# SPRINGS AT WATERVIEW ZONING MAP

LOCATED IN THE NW 1/4 OF SECTION 7, T15S, R65W OF THE 6TH P.M.,  
EL PASO COUNTY, STATE OF COLORADO

PROJECT: SPRINGS AT WATERVIEW  
SHEET TITLE: ZONING MAP  
FROM: n/a TO: n/a  
JOB NO.: 0001-02-16-01 SHEET 1 OF 1

SPRINGS AT WATERVIEW ZONING MAP

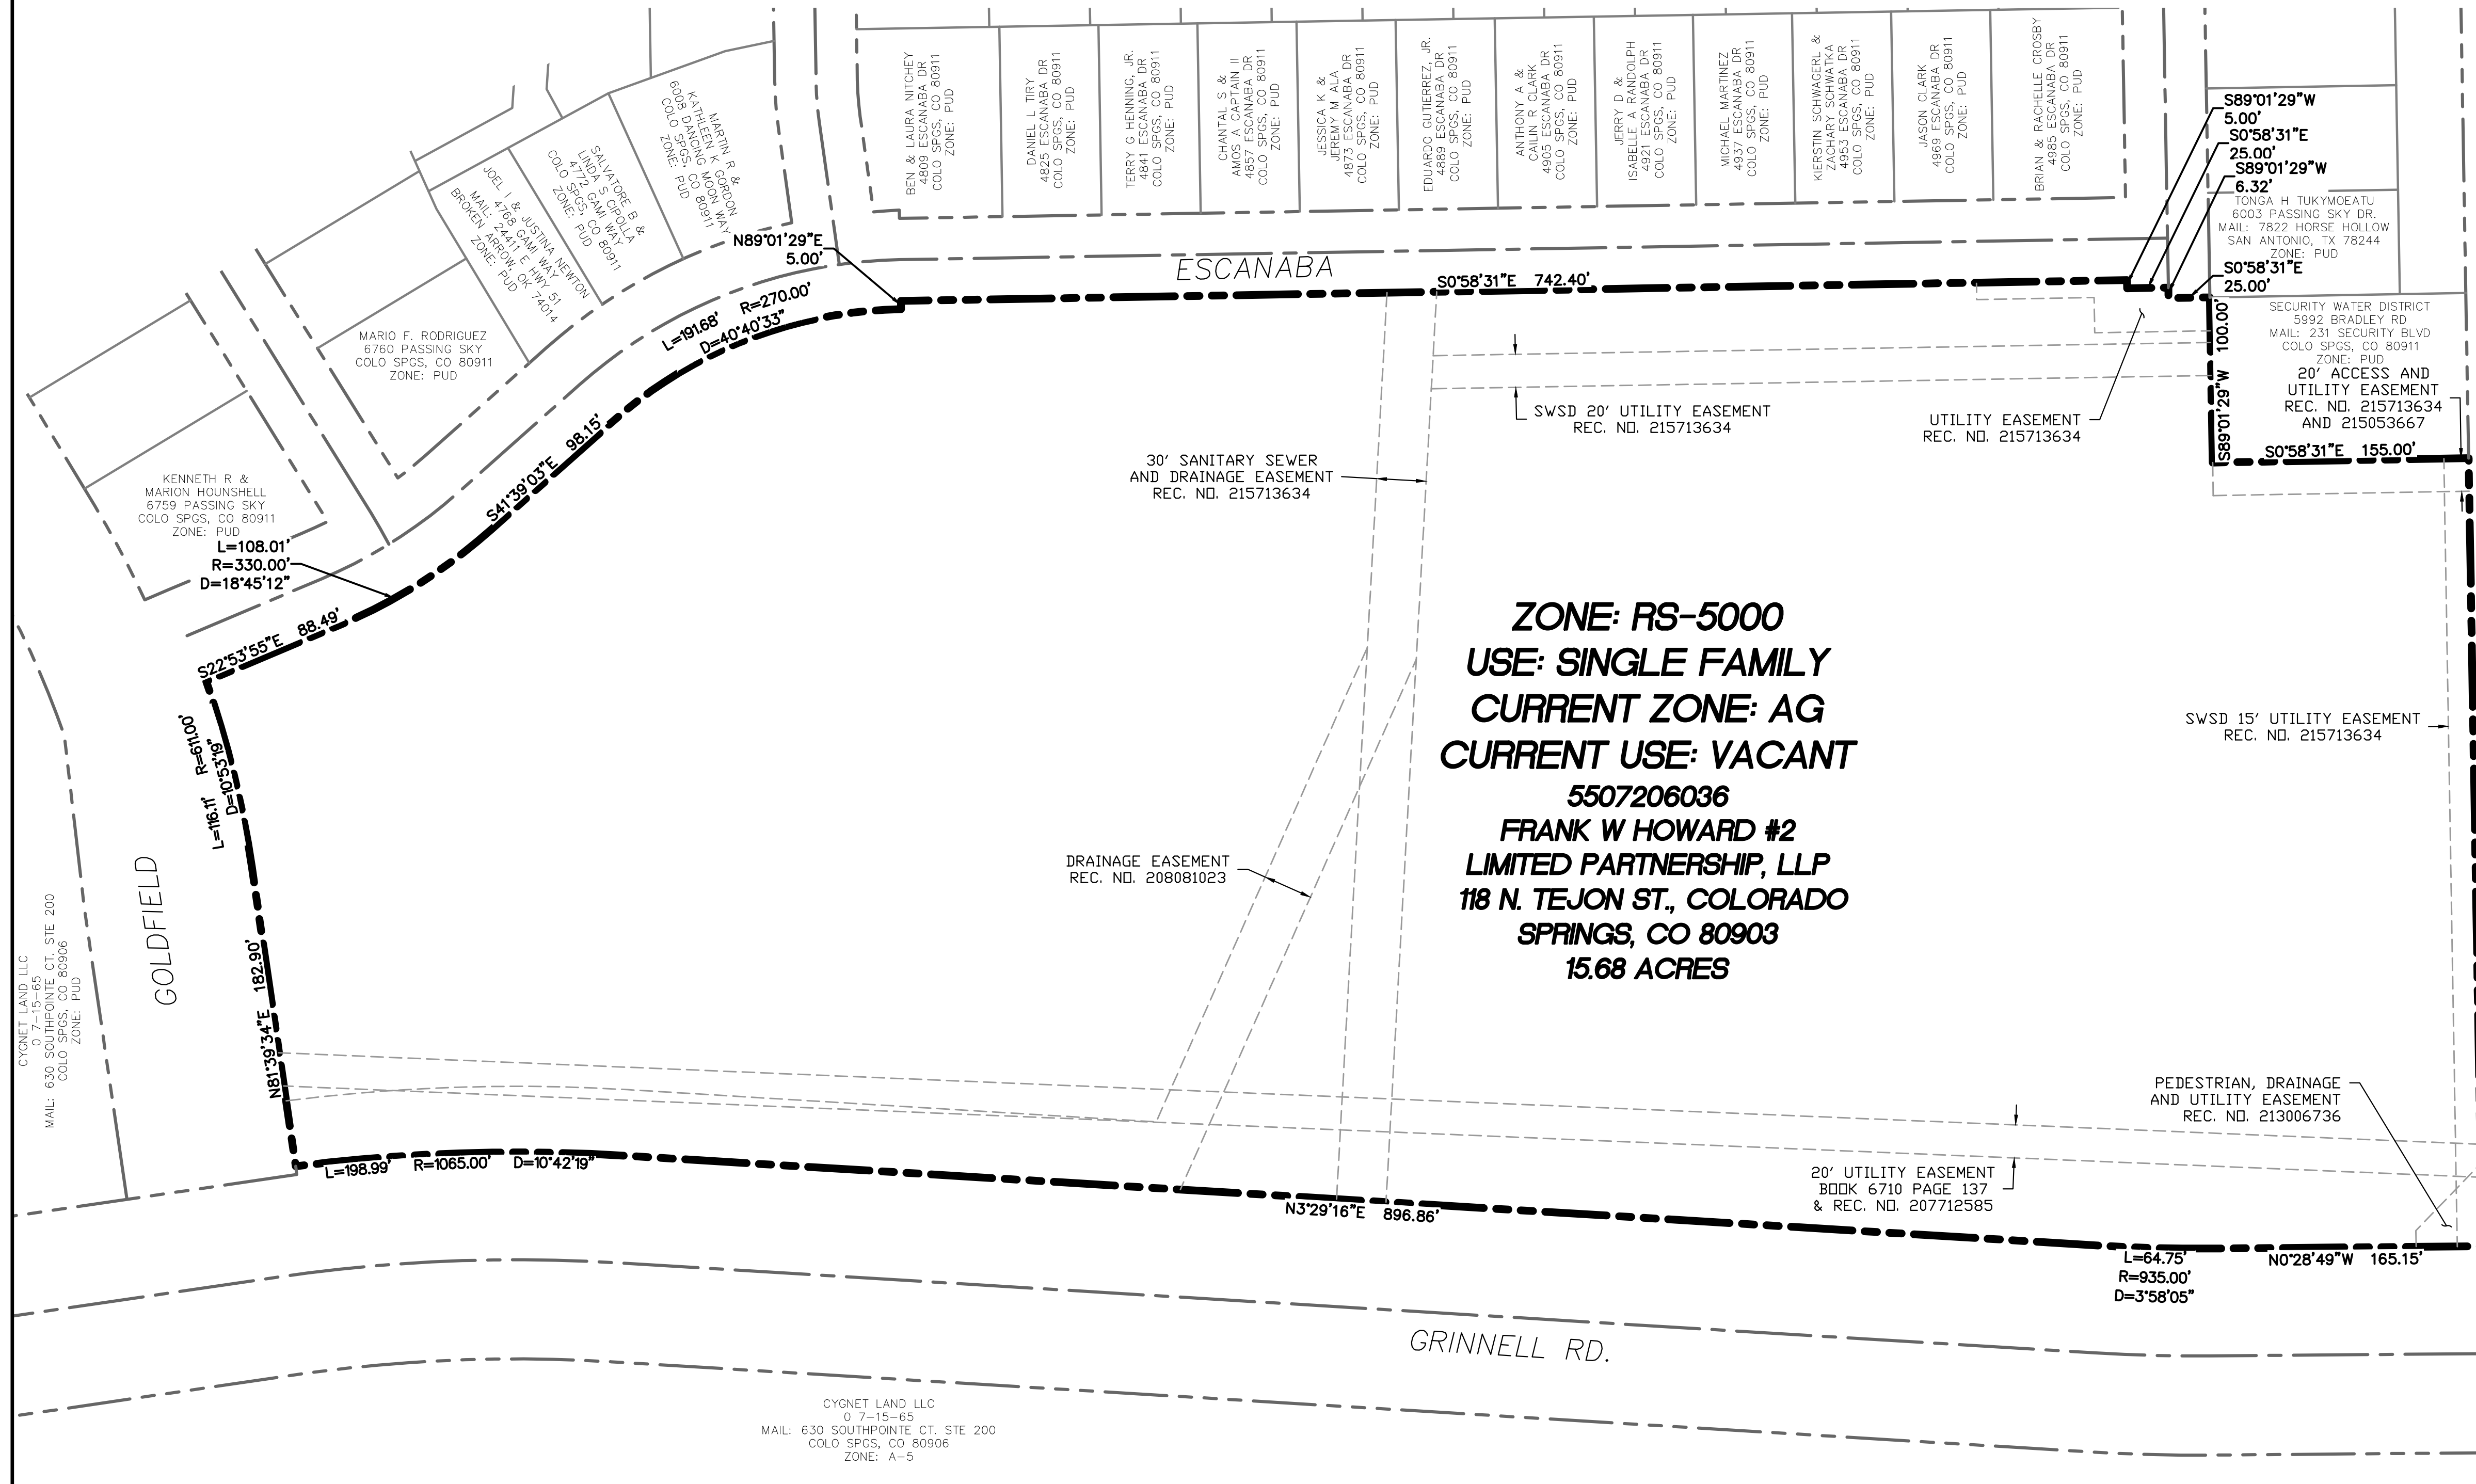
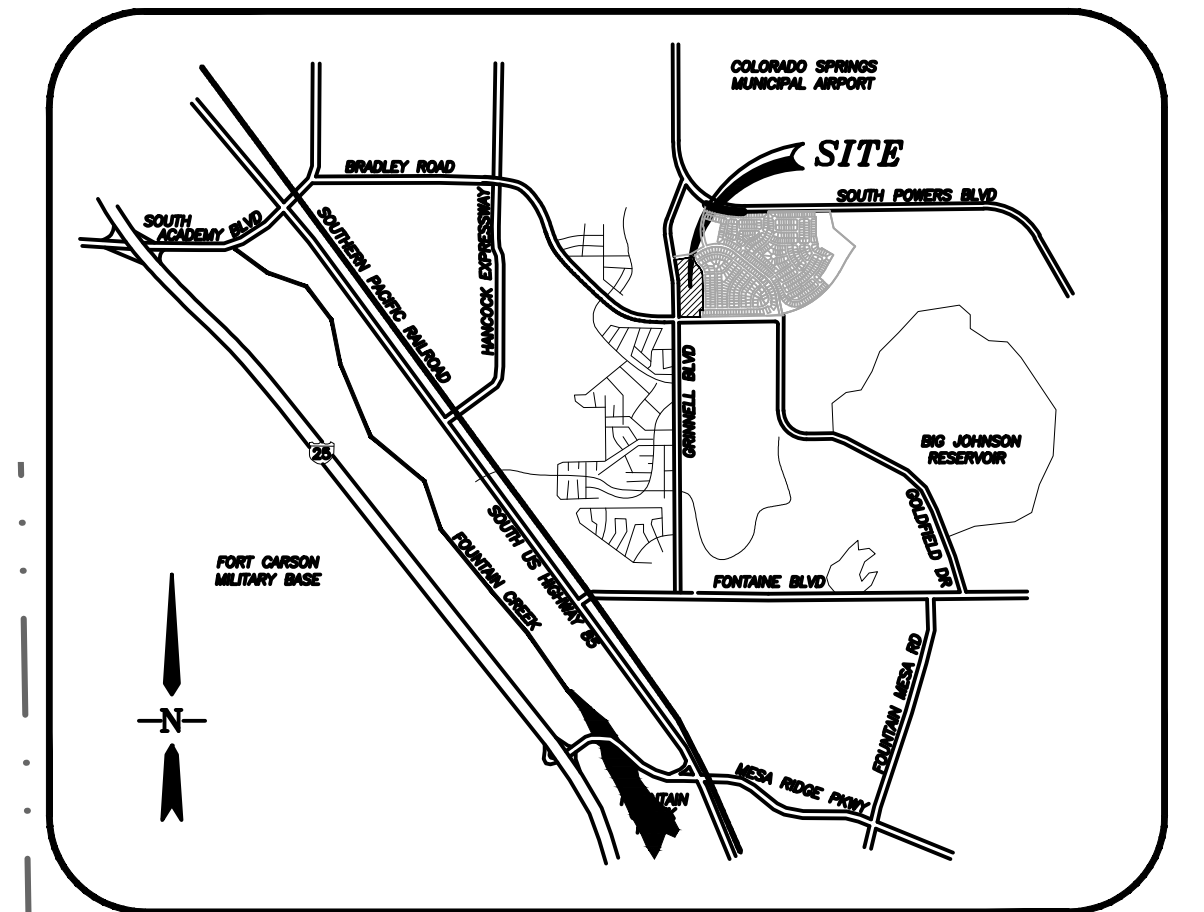
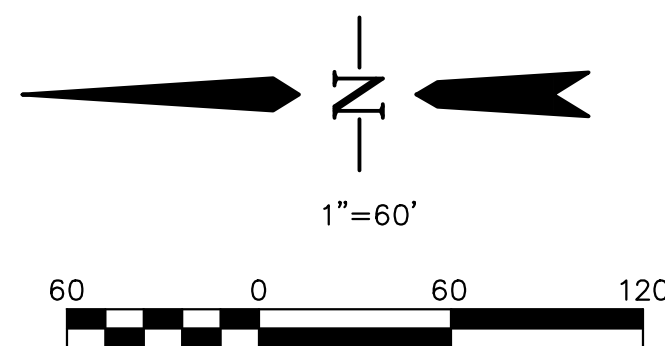
Please add all items required on the rezoning map checklist. The proposed lot lines need not be shown.

No longer a PUD request. Please revise all.

revise existing and proposed zoning to reflect request.
